### CITY OF ALBUQUERQUE

## PLANNING DEPARTMENT **November 18, 2009 DRB Comments**

**APPLICATION # 09-70342** PROJECT # 10005094

RE: Lots 7-B & 8, Block A, Grande Heights Addition

TRAFFIC CIRCULATION LOTS 7C, 7D, & 7E
& E-W CROSS-SECTION FULL SITE
OWNER: ESTRELLA VISTA DEVELOPMENT, INC.
CONTACT PERSON: JOE WAID

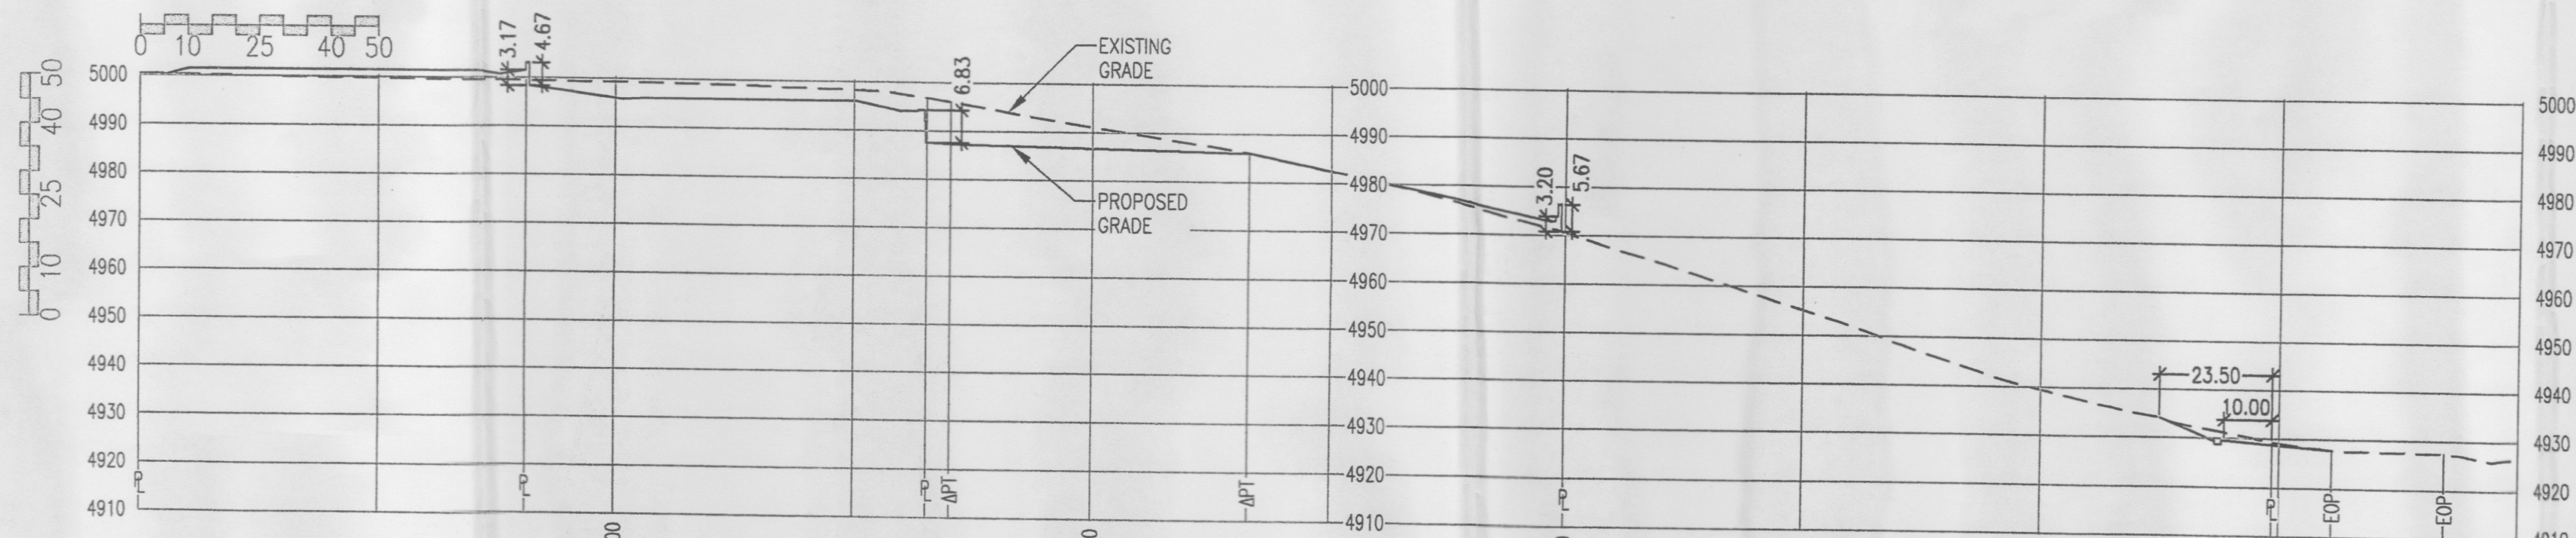
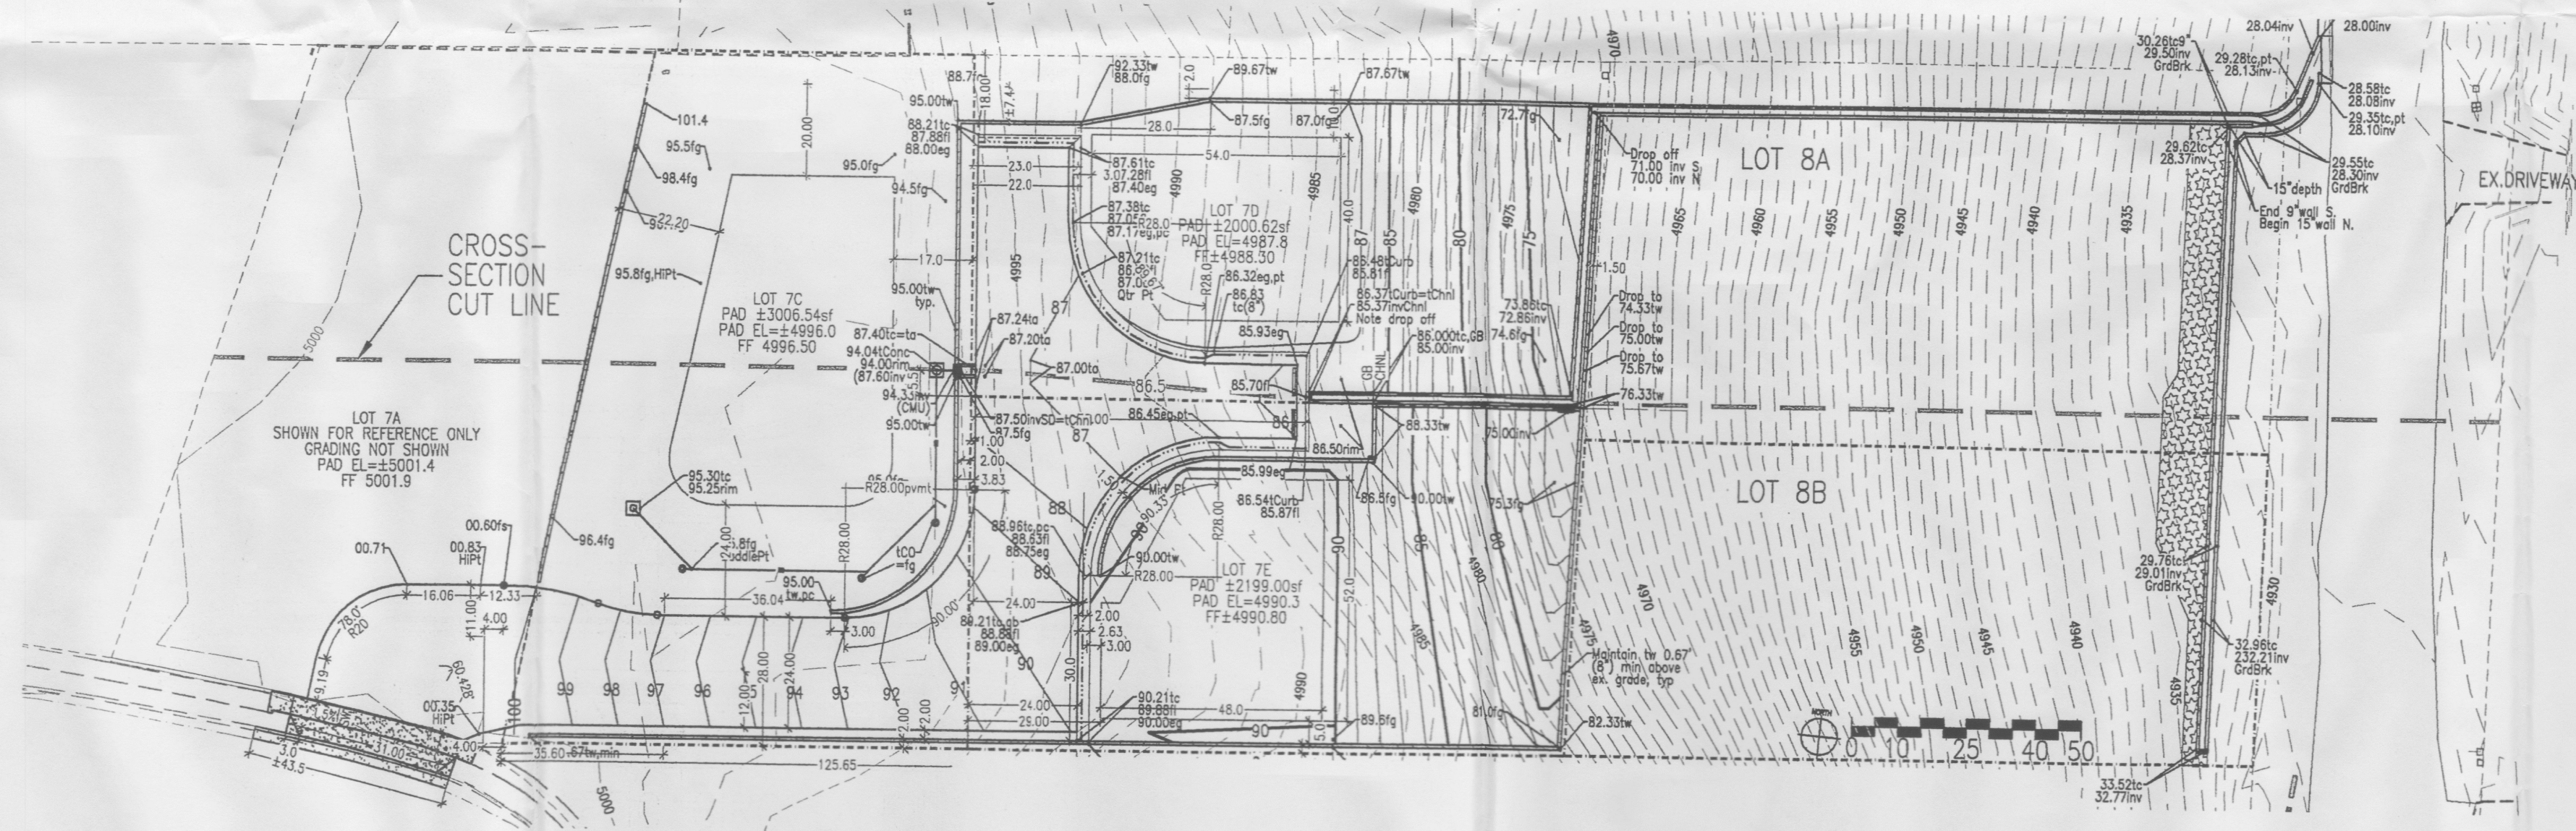
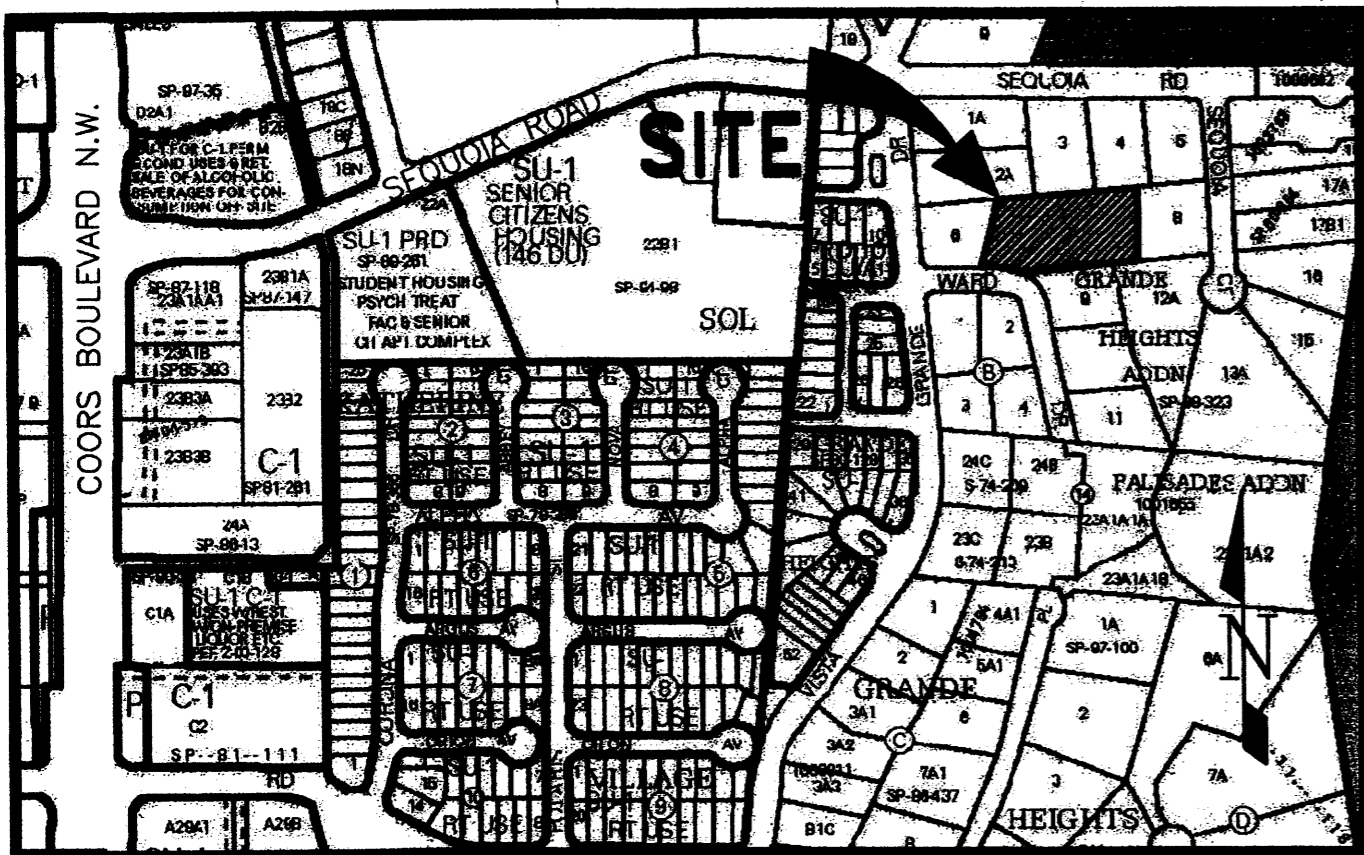
The topography of the site raises significant questions regarding Land Suitability - Section 14-14-2-3 of the Subdivision Ordinance. The height and treatment of retaining walls needs to be resolved prior to platting. An east-west cross section of the property is needed, showing existing and proposed topography.

Access via the proposed easement needs to be addressed – typically the maximum number of lots on a 26 foot easement would be three, but it appears this easement would be serving four lots (7-A, 7C, 7D and 7E).

**PLAT
OF
LOT 7-A & 7-B, BLOCK A
GRANDE HEIGHTS ADDITION**

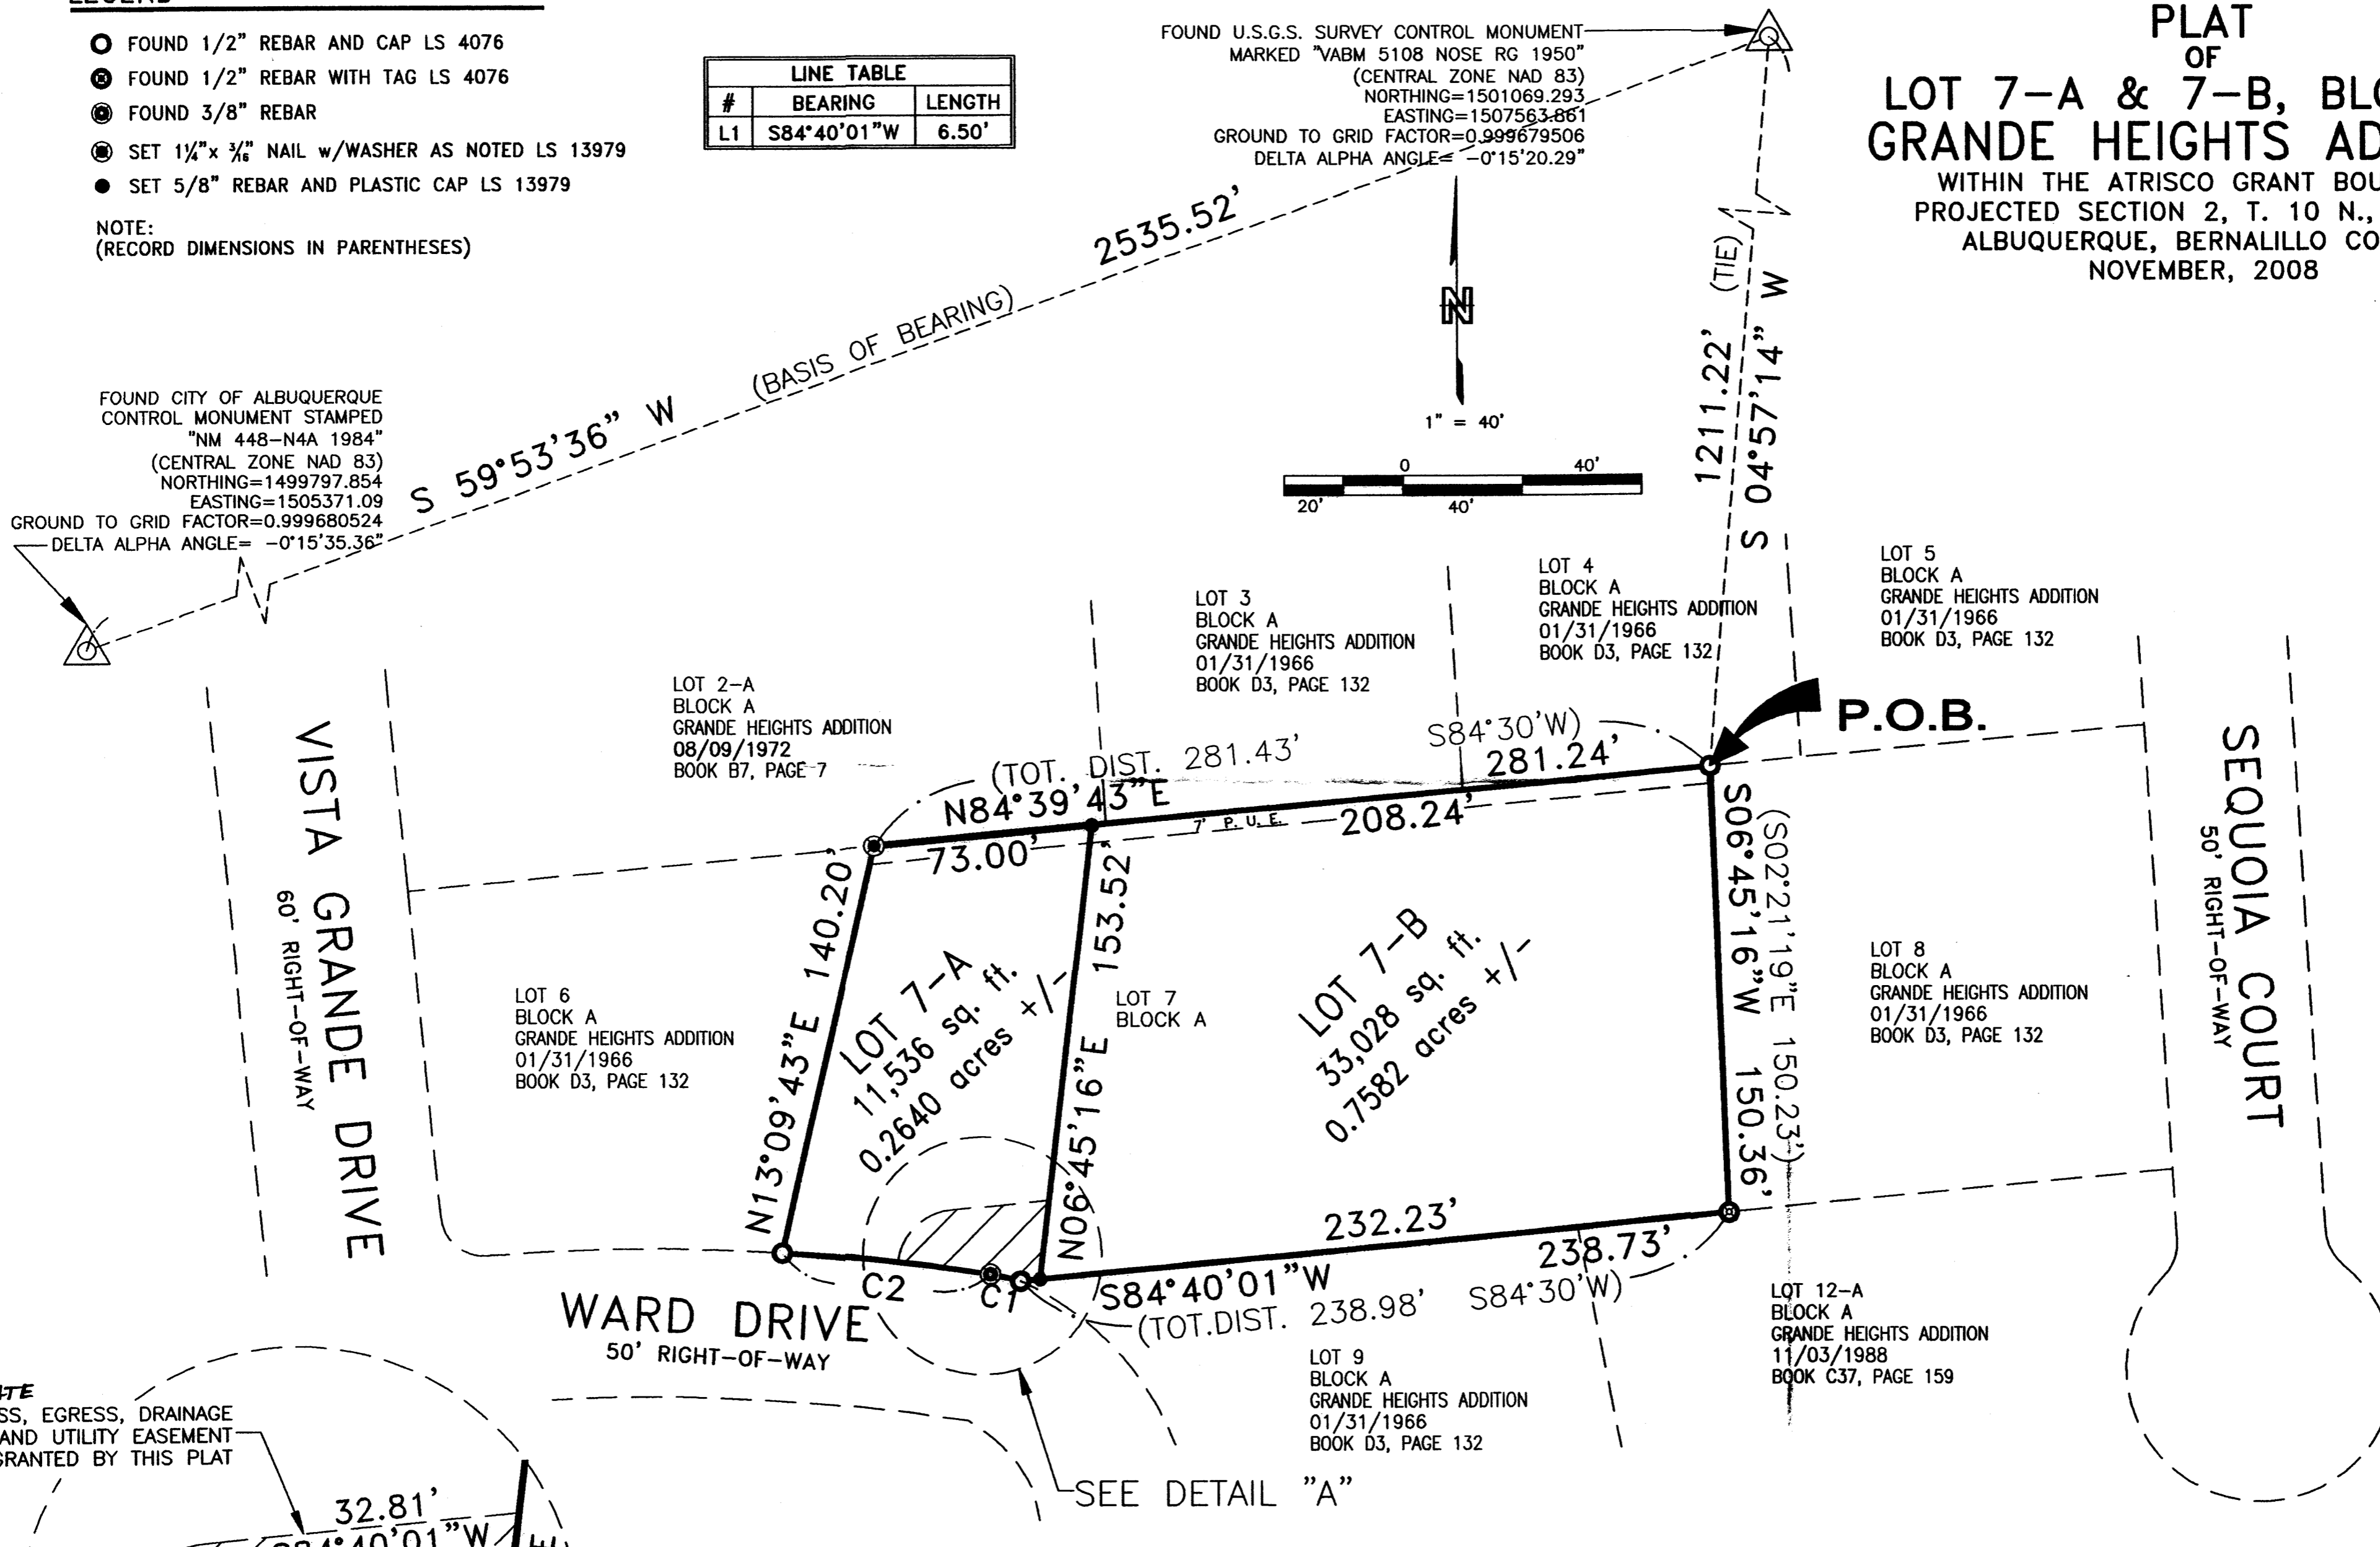
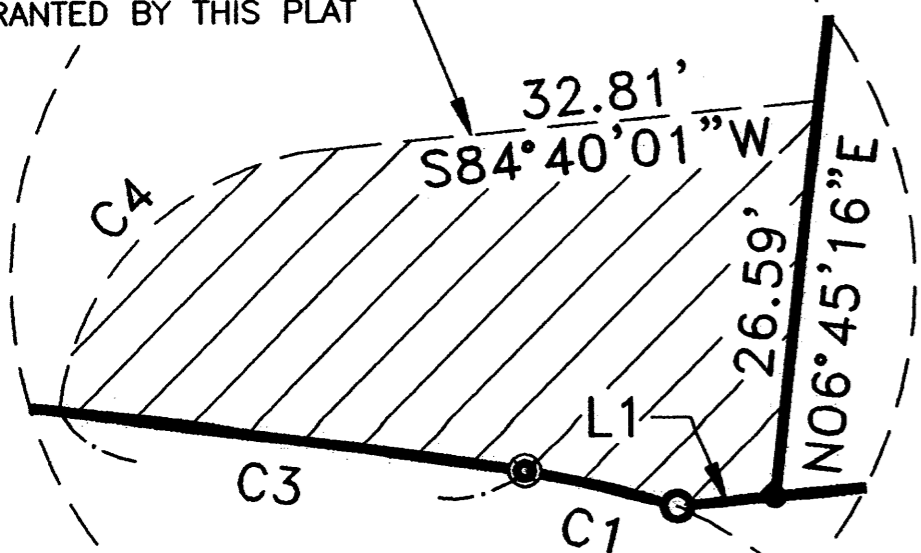
The topography of the site raises significant questions regarding Land Suitability – Section 14-14-2-3 of the Subdivision Ordinance. A note needs to be added to the plat which states "Development of Lot 7-B will be subject to an engineered development plan and appropriate easements on the adjoining, downstream Lot 8.".

A Solar Note needs to be on the plat (consistent with Section 14-14-4-7 of the Subdivision Ordinance) which is specific to this type of request, i.e. use the words "THIS PLAT" (rather than the words "REQUESTED FINAL ACTION") at the beginning of the note, and do not use the words "OR SITE DEVELOPMENT PLAN FOR SUBDIVISION" at the end of the note.

The maintenance and the beneficiary of the Private Easement needs to be noted on the plat (e.g. "to benefit and be maintained by the owner of Lot 7-B).

- 1. DEVELOPMENT OF LOT 7-B WILL BE SUBJECT TO AN ENGINEERED DEVELOPMENT PLAN AND APPROPRIATE EASEMENTS ON THE ADJOINING, DOWNSTREAM LOT 8.
- 2. NO PROPERTY WITHIN THE AREA OF THIS PLAT SHALLS ANY TIME BE SUBJECT TO A DEED RESTRICTION, COVENANT, OR BINDING AGREEMENT PROHIBITING SOLAR COLLECTORS FROM BEING INSTALLED ON BUILDINGS OR ERECTED ON THE LOTS OR PARCELS WITHIN THE AREA OF PROPOSED PLAT. THE FOREGOING REQUIREMENT SHALL BE A CONDITION TO APPROVAL OF THE PLAT.
- 3. THE PRIVATE INGRESS, EGRESS, DRAINAGE & UTILITY EASEMENT ARE FOR THE BENIFIT AND USE BY THE OWNER(S) OF LOT 7-B AND IS TO BE MAINTAINED BY THE SAID OWNER(S).
